# Rezoning Transportation Analysis

Petition Number: 2022-115

## Revision Log:

Date	Description
12-28-22	First Review (TM)

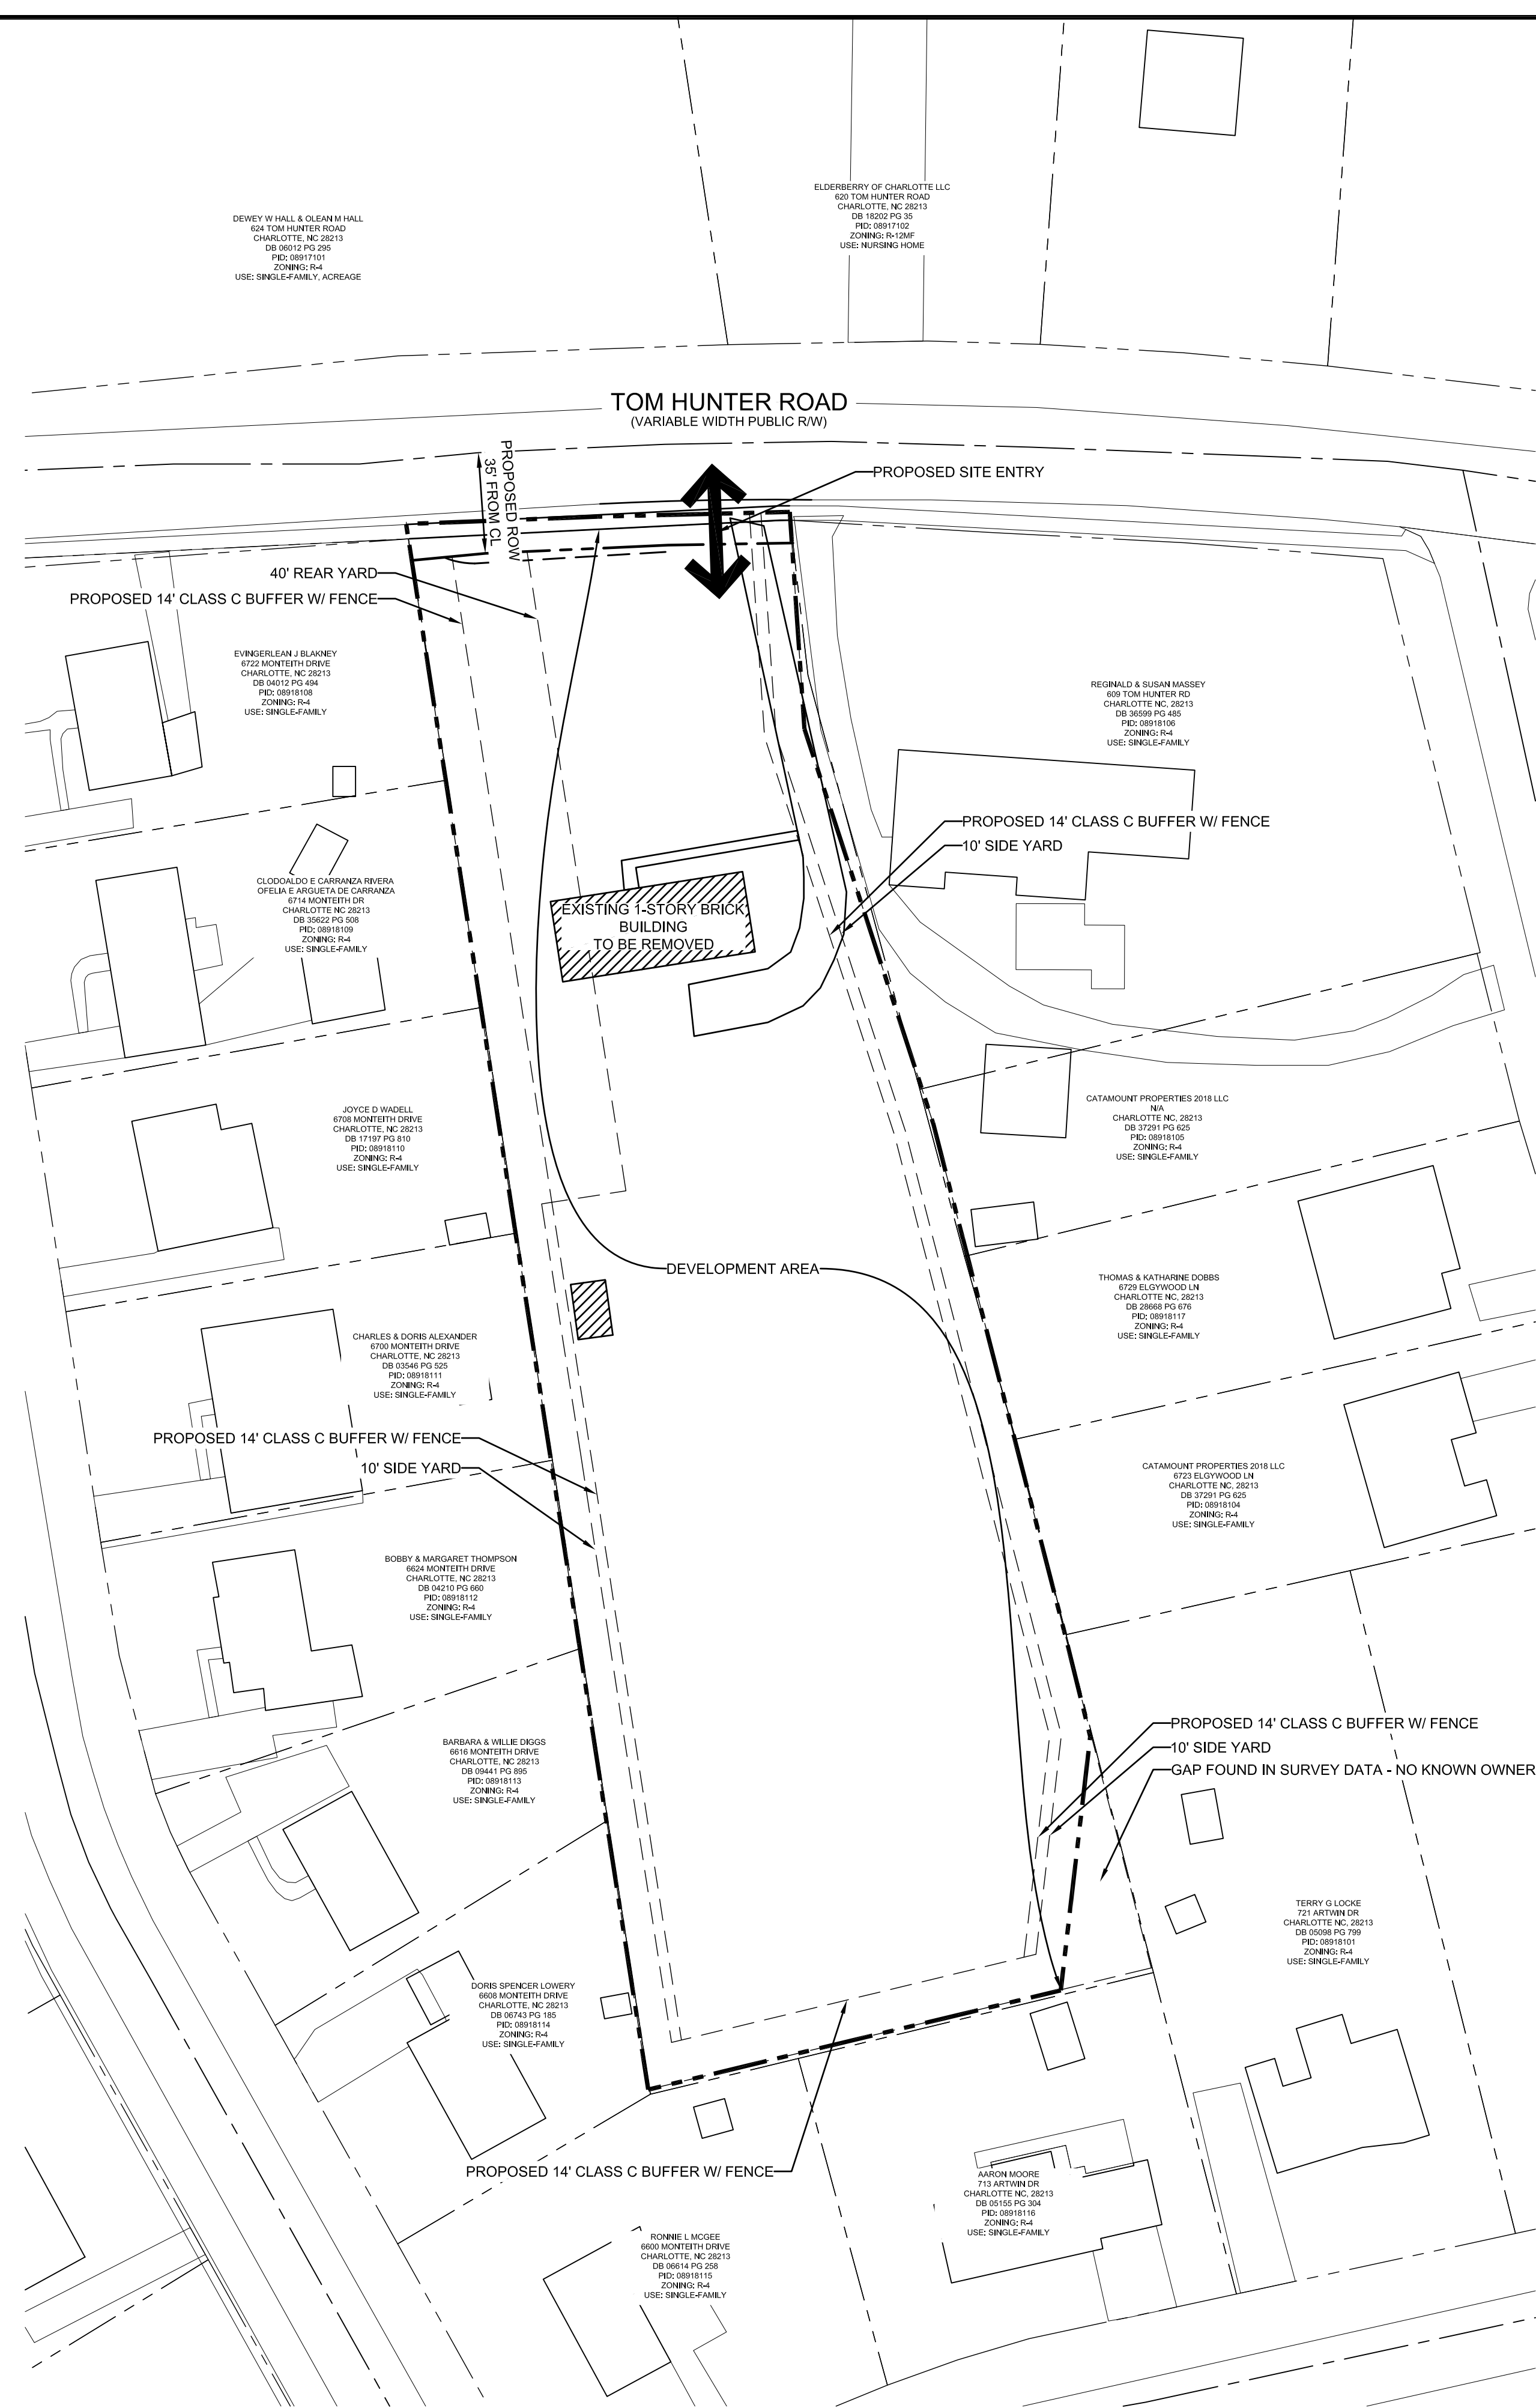
- a. **Tom Hunter Road:** Location of back of curb and gutter to be moved to 24 feet from roadway centerline to accommodate the Charlotte Streets Map with a roadway typical section of CLDSM 11.09 Minor Thoroughfare.

Label and dimension the curb and gutter from the centerline for each road on the site plan.

3. Revise site plan and conditional note(s) to commit to construct an 8-foot planting strip, and 8-foot sidewalk on Tom Hunter Road per Chapter 19. The site plan shall label and dimension both items from the back of curb and gutter or edge of pavement.
4. The proposed dwelling units exceeds 12 per acre. Per Chapter 20 Subdivision ordinance, revise site plan and conditional note(s) to commit to construct an 8-foot planting strip, and 8-foot sidewalk along Tom Hunter Road. The wider sidewalk also meets the Charlotte WALKS Policy.

5. Revise site plan and conditional note(s) to commit to construct bicycle facilities by locating the curb and gutter 24' from the center line/installing a buffered bike lane to meet the Council-adopted Charlotte BIKES Policy.
6. Add a conditional note specifying "A Right-of-Way Encroachment Agreement is required for the installation of any non-standard item(s) (irrigation systems, decorative concrete pavement, brick pavers, etc.) within a proposed/existing City-maintained street right-of-way by a private individual, group, business, or homeowner's/business association. An encroachment agreement must be approved by CDOT prior to construction/installation. Contact CDOT for additional information concerning cost, submittal, and liability insurance coverage requirements."
